**Offshore Wind Farms**  
EAST ANGLIA ONE NORTH  
PINS Ref: EN010077  
and  
EAST ANGLIA TWO  
PINS Ref: EN020078  
Deadline 9

SEAS (Suffolk Energy Action Solutions)  
EA1N – EN010077 / SEAS ID no 2002 4494  
EA2 – EN010078 / SEAS ID no 2002 4496

Response by SEAS to the Applicant's Comments on NE's Deadline 7:  
*4 Applicants' Comments on NE Appendix C8 [REP7-073] – NE's Response to the Ecology Survey Results [REP6-035]*  
<https://infrastructure.planninginspectorate.gov.uk/wp-content/ipc/uploads/projects/EN010077/EN010077-004502-ExAAS-17.D8.V1%20EA1N%20EA2%20Applicants'%20Comments%20on%20Natural%20England's%20Deadline%207%20Submissions.pdf>

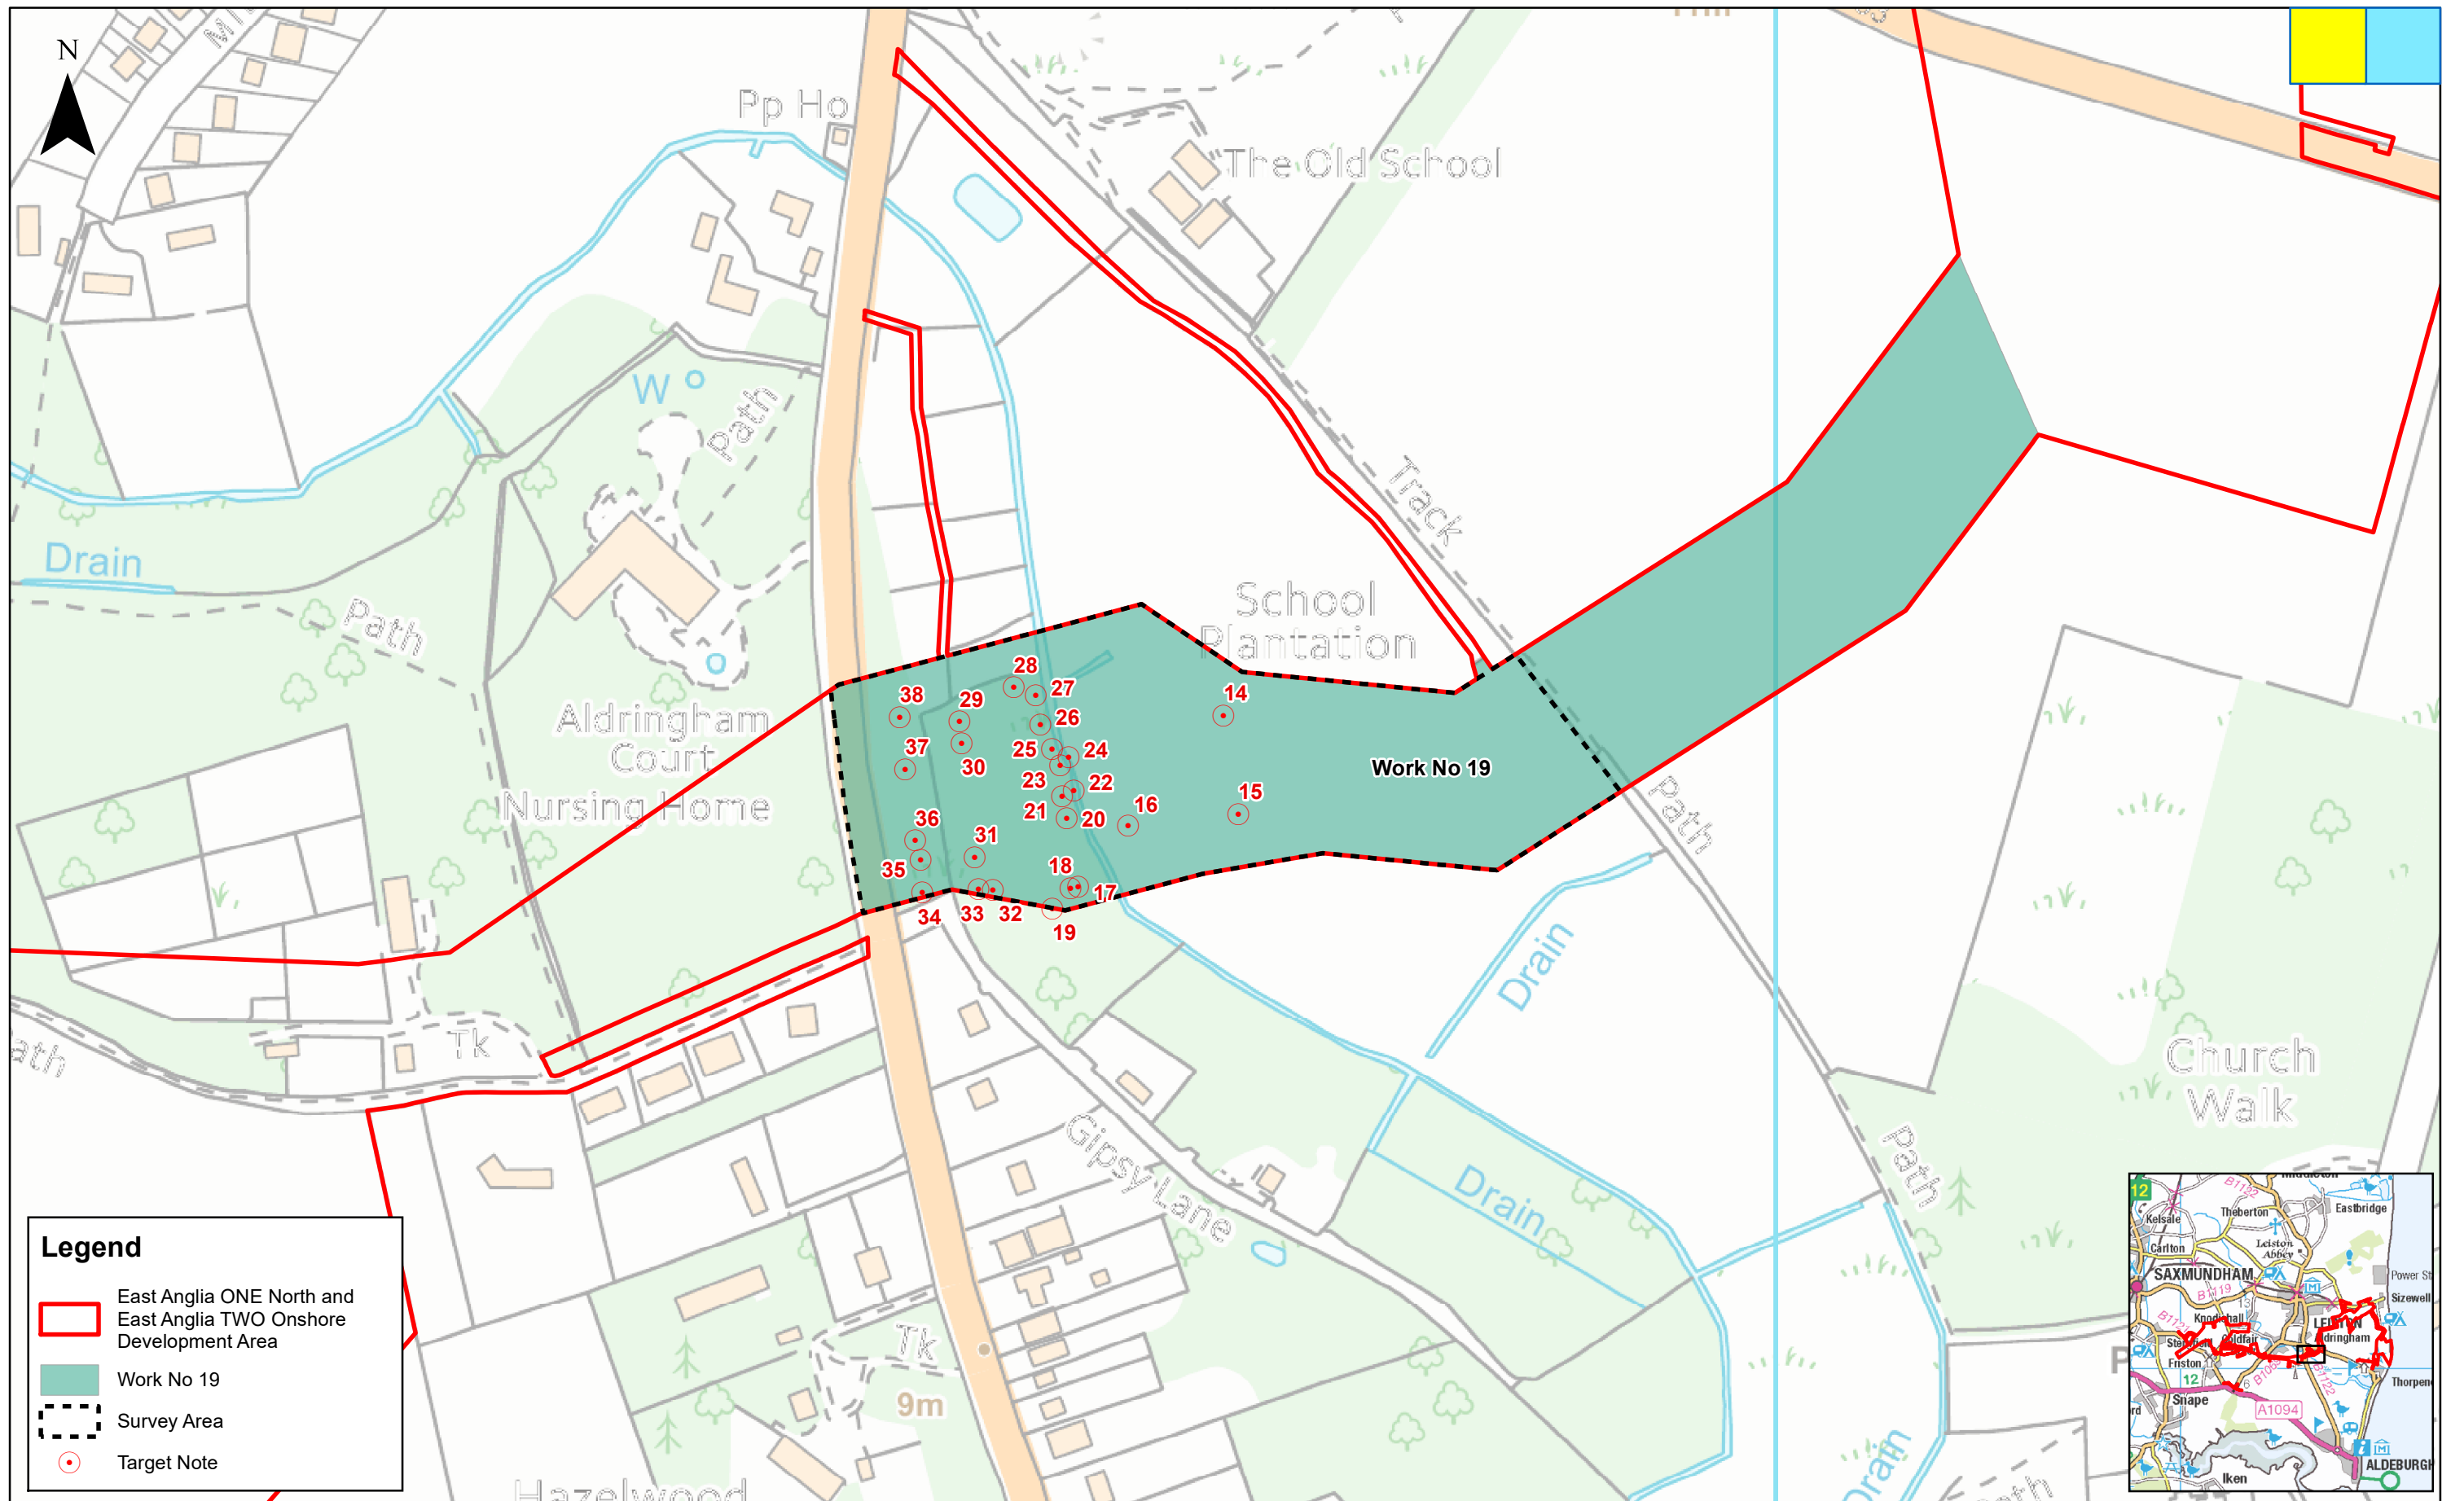
The 'Guidelines' cited recommend identifying priority habitats at P1 /including during desktop surveys. The priority riparian woodland was missed at this stage (as were wet meadow, arable and hedgerow environments, for that matter). NVC classification requires a wet woodland assessment in late spring or summer, not winter. 'Guidelines' say that further surveys should be undertaken if rare or priority elements are suspected (pp 31 ff) - which should be according to specific criteria and compared to national and local baselines This has not been carried out, nor has correction and accordance of priority status been fed into the plans for watercourse crossing. (SEAS described at deadline 8 the P1 surveys in which omissions and errors occurred, and on which plans for watercourse crossing, SSSI crossing and felling of priority woodland are still founded.)

1 At this time Natural England believes it would be inappropriate to provide further scientific advice based on this survey alone due to survey limitations.

2 Whilst Natural England notes the Applicants want to be helpful in providing the necessary evidence, unfortunately the survey hasn't followed standard best practice in relation to the timing and ground conditions. Many vegetation species are only evident in spring or summer and these are really important in identifying the habitat type and its quality. To have the degree of confidence required in habitat surveys at this time of year we would expect a botanist with FISC 5/6 would undertake the survey.

3 In addition, for undertaking surveys at the appropriate time of year and appropriate level, we advise that a National Vegetation Classification survey might be required to prove or disprove the quality of the habitats.

Please see 1C above. P1 surveys were suboptimal and also took place, from the photos, before spring was showing, which was again the wrong time of the year.

The woodland is a priority environment. Yet 44% will be felled at the crossing.

The Applicant has planned the cable corridor without acknowledging or accounting for the riparian environment. They have no other riparian site to replant, and not enough land has been allocated to woodland replacement in the plans. The only mitigation they can offer is to shave a metre or so off the trenching. This is shockingly inadequate. If a woodland is suspected of being in NVC's wet category the whole site should be surveyed and not simply the order limits.

The Applicants are disappointed that NE continues to question the classification of the woodland at the Hundred River crossing despite the evidence provided by the Applicants.

All surveys undertaken to date have been in accordance with the 'Extended Phase 1' methodology as set out in Guidelines for Baseline Ecological Assessment (Institute of Environmental Assessment, 1995) and by suitably qualified professional ecological surveyors. Across the ecological profession, it is accepted that Phase 1 habitat surveys can be conducted all year round. However, the Applicants acknowledge that the optimum time to have undertaken the February 2021 survey would have been between April and September.

The Applicants maintain that the woodland at the Hundred River crossing is semi-natural broadleaf woodland.

This conclusion is supported by the independent site visit undertaken by the Councils, as confirmed verbally at Issue Specific Hearing 7 and subsequently by ESC in its written submission at Deadline 6 (REP6-075). ESC states *"we agree with the habitat characterisation of area as set out in the ES. We do not consider that the area within the red line boundary is wet woodland as defined by the JNCC"*.
